From: Karl Roberts <Karl.Roberts@arun.gov.uk>
Sent: 19 December 2019 16:47
To: Planning.Responses <Planning.Responses@arun.gov.uk>
Subject: FW: A/100/19/PL - Arundel Acre - response to WSCC

From: Ian Hayward <[REDACTED]>
Sent: 19 December 2019 08:35
To: Joney Ramirez <[REDACTED]>
Cc: Karl Roberts <[REDACTED]>
Subject: RE: A/100/19/PL - Arundel Acre - response to WSCC

Visibility North & Highways England:

WSCC (LHA)

Appendix D – Drawing No: JNY10317/02

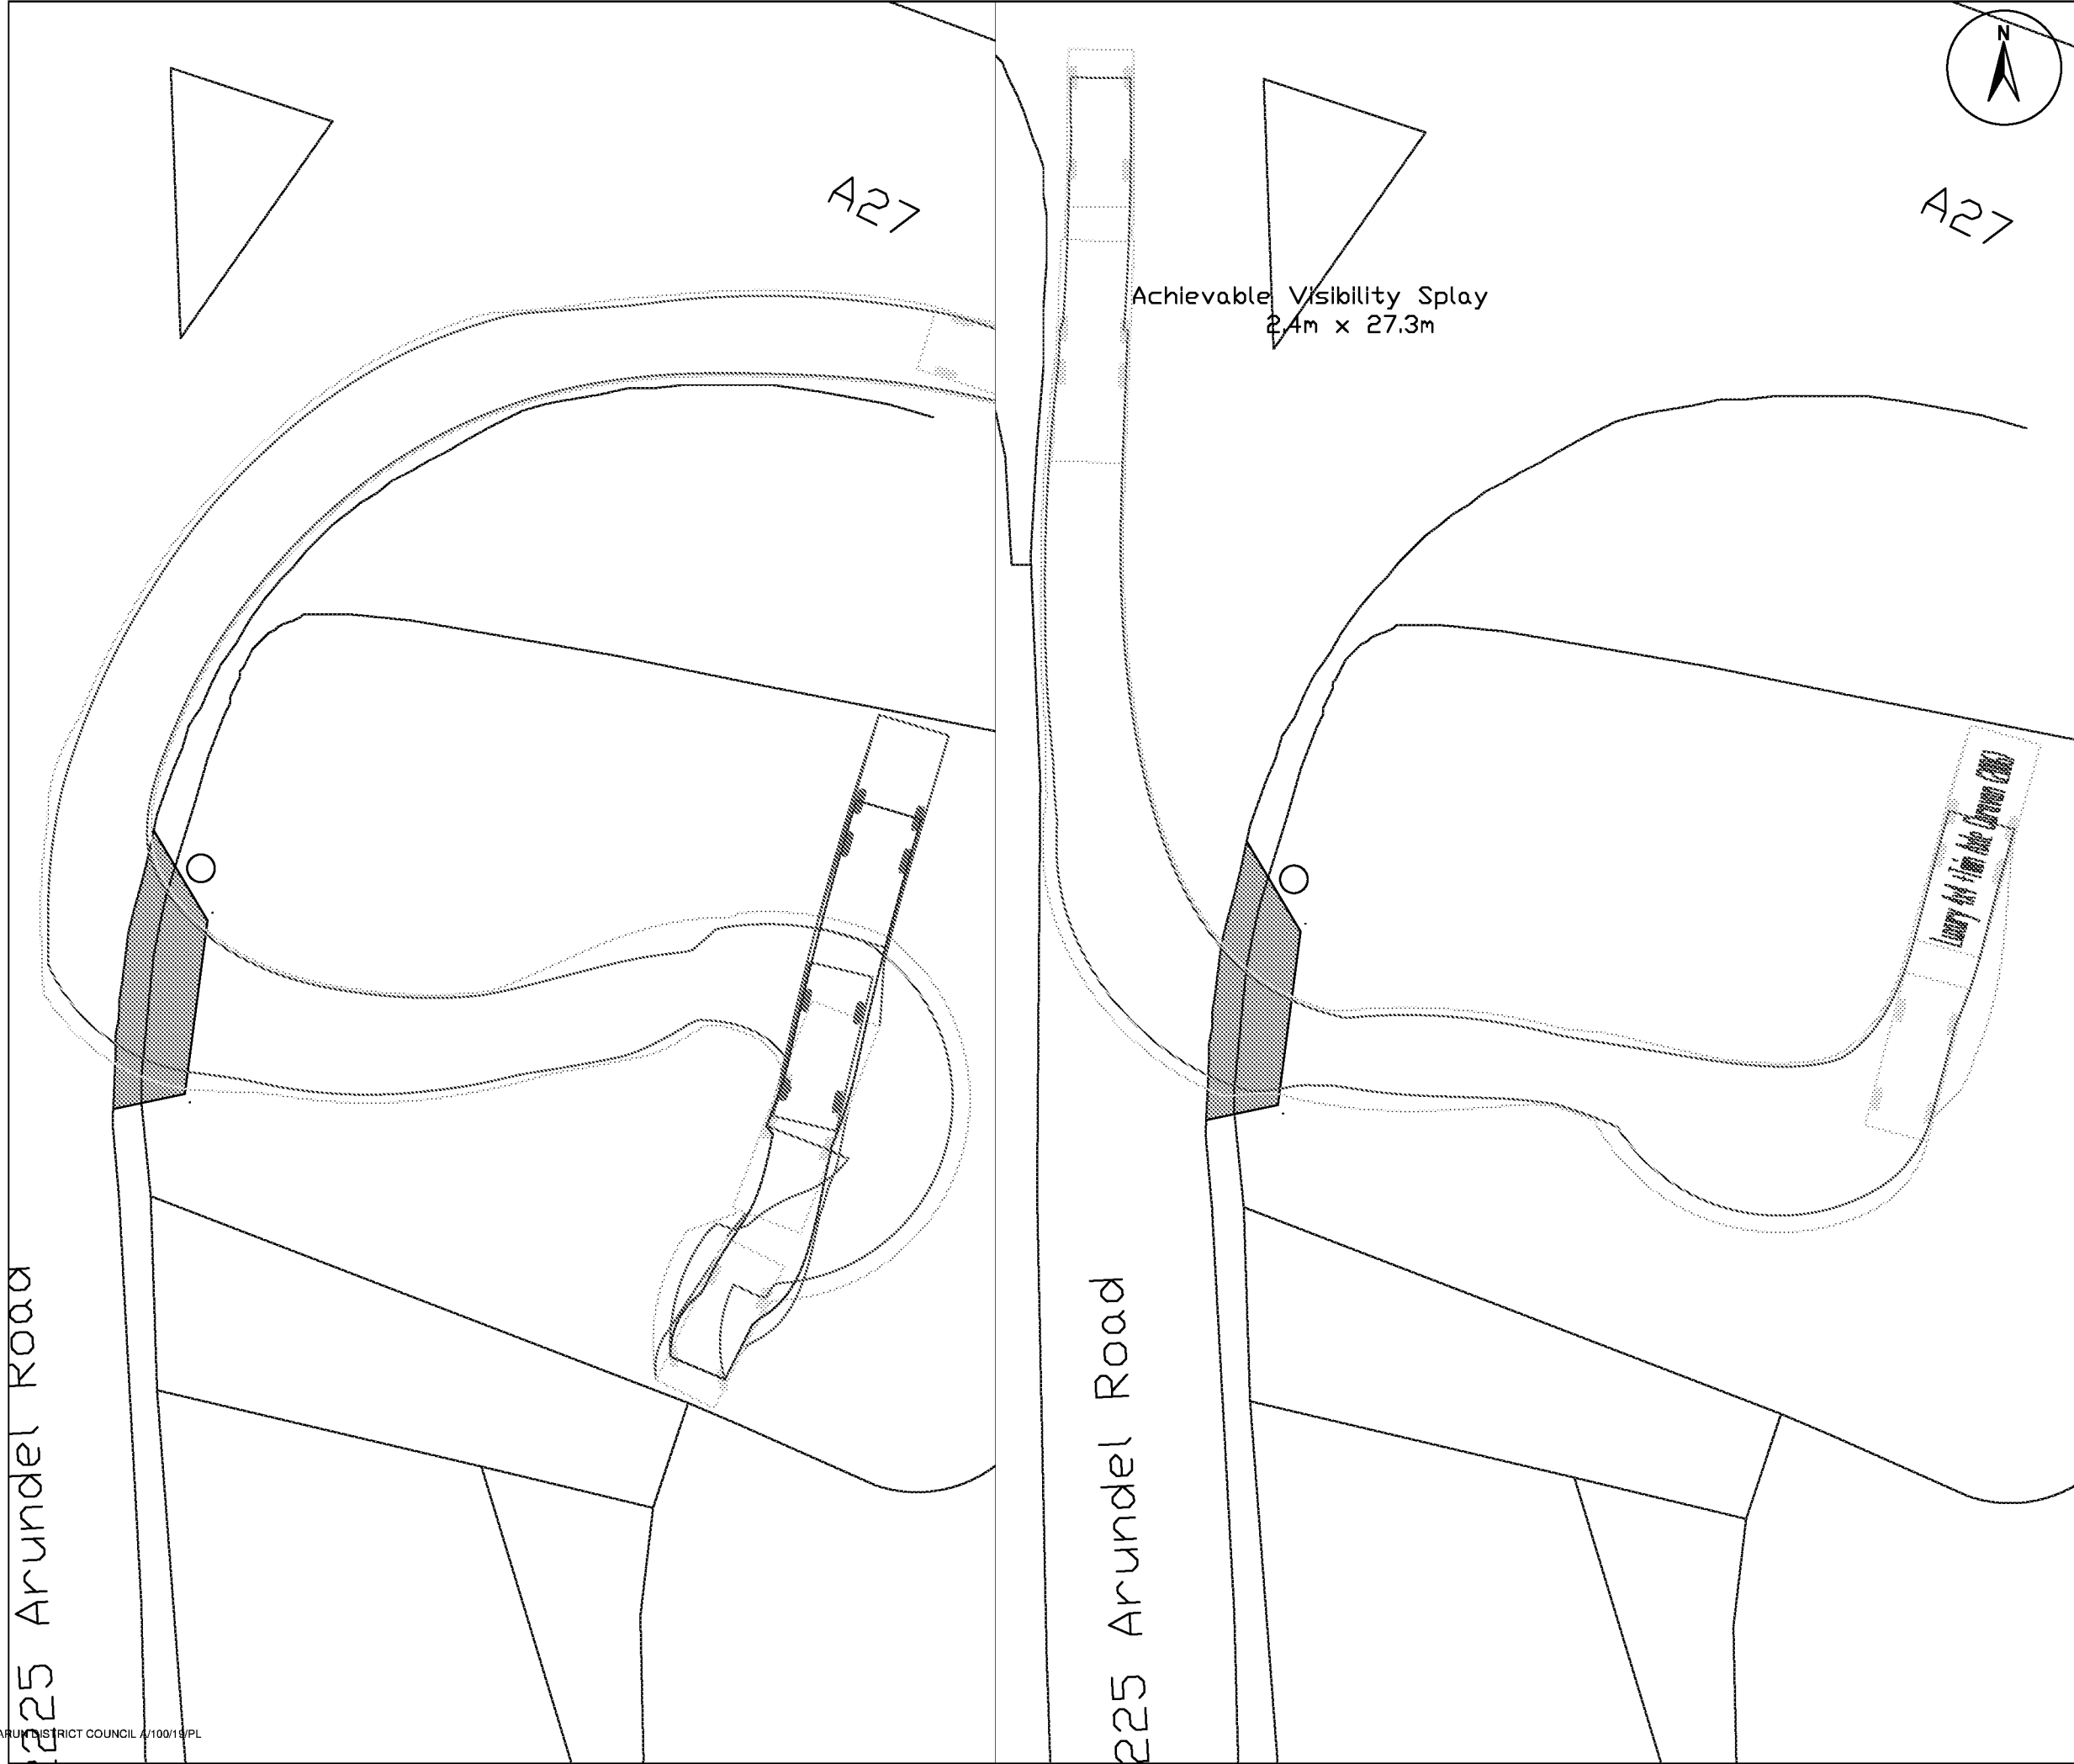
- iv) Noted, the Local Planning Authority advised to ensure this is the case. Scaling of the currently submitted red edge Location Plan makes this difficult to determine. For clarity highlighted below is the area that the Local Highways Authority had previously queried as potentially being 3rd party land but required to formulate the visibility splays.

- v) The statement made in Paragraph 10.5.9 of Manual for Streets 2 (attached below) references a research study. This study was undertaken using a series of high-risk, urban, established priority junctions, of which the application site access is not. It is therefore questionable how applicable this paragraph is in this particular case. The research was also undertaken using a 2.4 metre 'X' distance for which only the demonstrated 25.5 metre splay would be considered applicable for comparison. While there is no local, evidence to the contrary, accident data etc., there would not be expected to be any given the low trip generation the access has yielded with its current use.

iv. **It is acknowledged an improvement over the existing situation; however it appears the southern splay will require the use of 3rd party land** – We welcome the LHA's acknowledgement that the proposed relocation of the access will represent an improvement compared to existing and, in order to provide clarification, the proposed splays **will not** require the use of 3rd party land.

v. **The southern splay is significantly short of what would be expected given the approaching road speed, with MfS requiring a stopping sight distance (SSD) of 50m** – The southern visibility splay would be able to achieve SSD between 25.5m – 30.1m and given other site's constraints, this would be the maximum achievable on site. It is the case that Paragraph 10.5.9 from Manual for Streets 2 indicates that, although the 'Y' distance of a visibility splay should be based on the recommended SSD, *"unless there is local evidence to the contrary, a reduction in visibility below recommended levels will not necessarily lead to a significant problem."* Taking into consideration: i) the number of two-way vehicular trips which will result from trailers or large vehicles will be less than 0.1 per day; ii) the nature of this part of the road, where there exist residential accesses with limited visibility which are similar in scale and nature to the proposed residential movements to be generated from the proposal, as well as the

RPS Drawing/Figure Number	Rev
JNY10317/01a	-

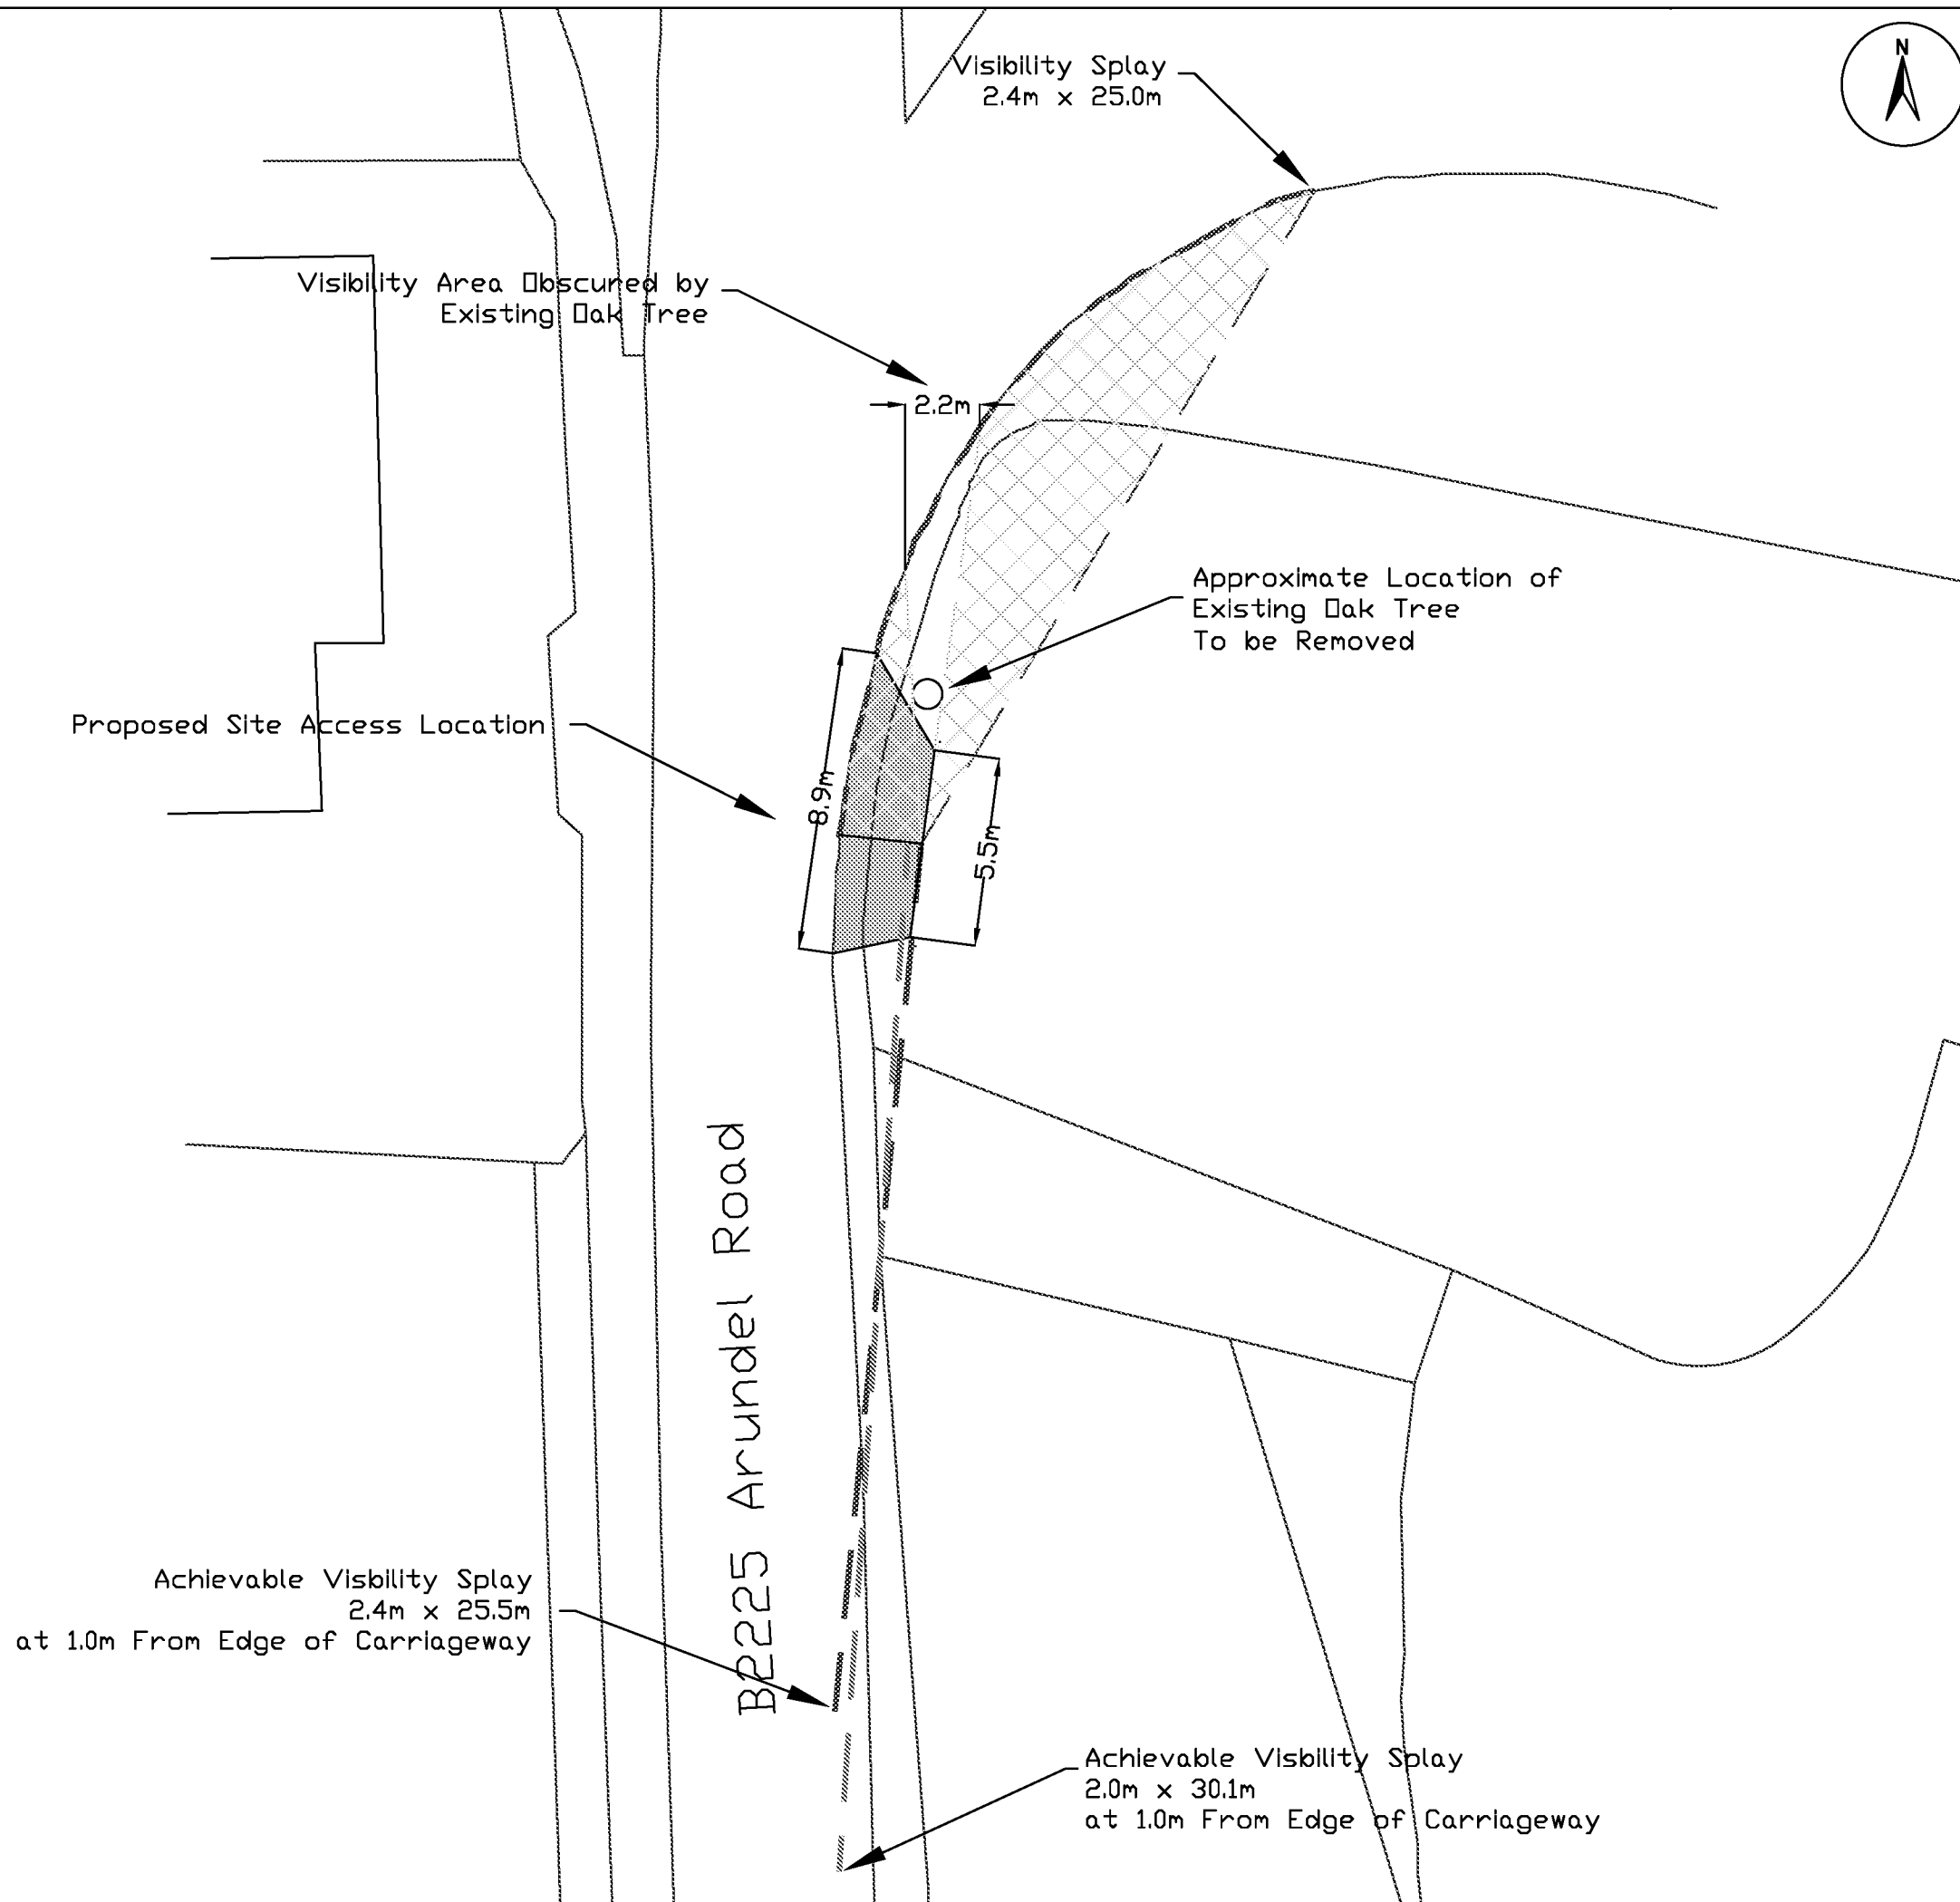
- ii) The Local Highways Authority accepts that subsequently additional plans submitted represent the site and surrounding road network accurately. However is minded to view that the submitted block plan (unnamed but dated 03/07/2017) does not represent the surrounding highway network accurately, particularly the junction with A27.

ii. **The block plan is not representative of the road layout and the deceleration lane would result in higher speeds approaching the access point** – Submitted drawing No. JNY10317/01a is based on OS mapping and accurately shows the road layout. Although lane delimitation is not shown, the submitted ATC, plans and supporting documents provide, in our view, an appropriate level of detail to allow the LHA to assess the proposal, with the ATC providing specific detail regarding speeds.
